Recommendation Report for Lawful Development Certificate for a Proposed Use or Development

REF NO: BN/27/21/CLP

LOCATION: 6 Nursery Close
Barnham
PO22 0JY

PROPOSAL: Lawful Development Certificate for a Proposed loft conversion with side dormer

DRAWING:
Proposed Elevations

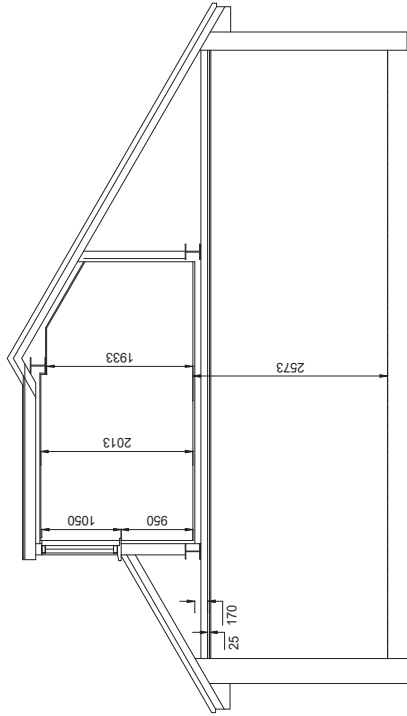
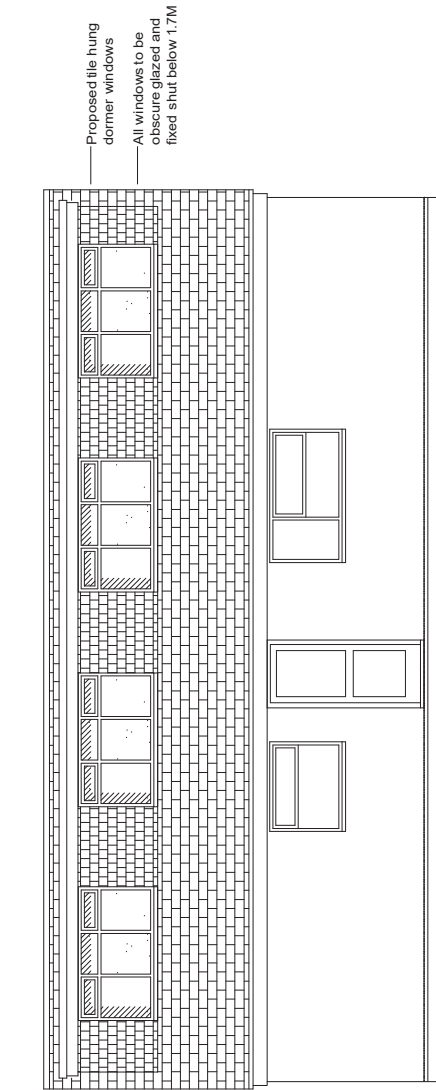
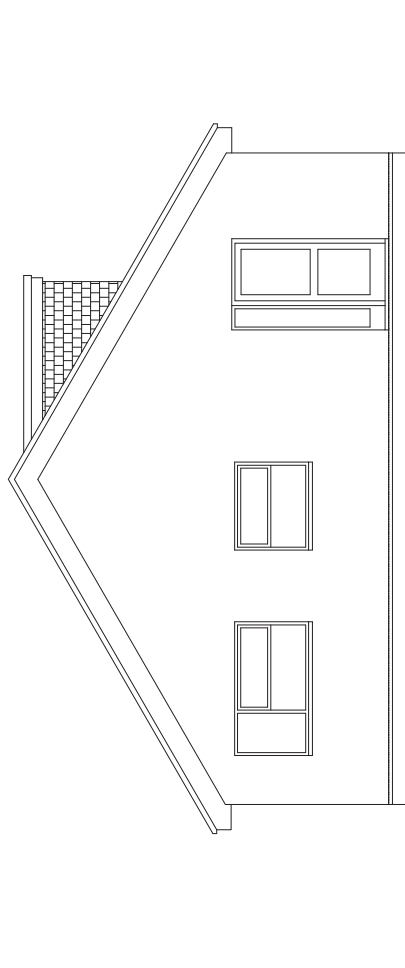
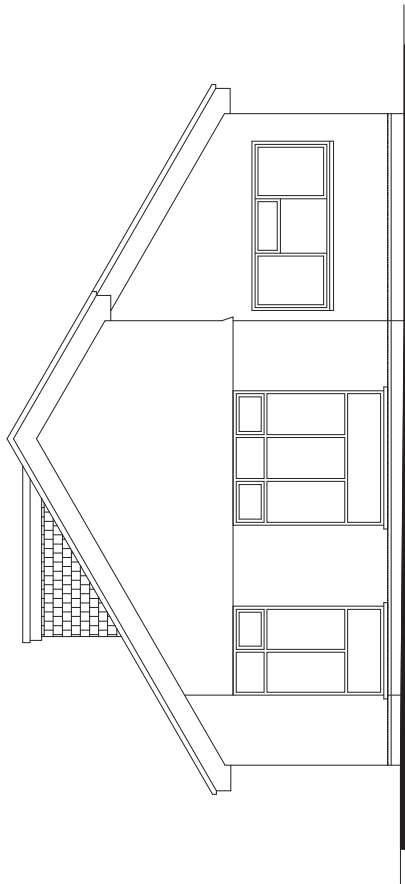
The proposed roof dormer complies with relevant sections B.1 and B.2 and is considered permitted development and as such does not require the submission of an application for full planning permission.

This development seeks a dormer roof extension to side of house, measuring approximately 11.4m in length by 2.2m in depth by 1.3m in height. Resulting in an additional 16m³ (approx..) of volume to the roof space. The 4 sets of windows to the North Eastern elevation shall be fixed shut below 1.7m and obscure glazed.
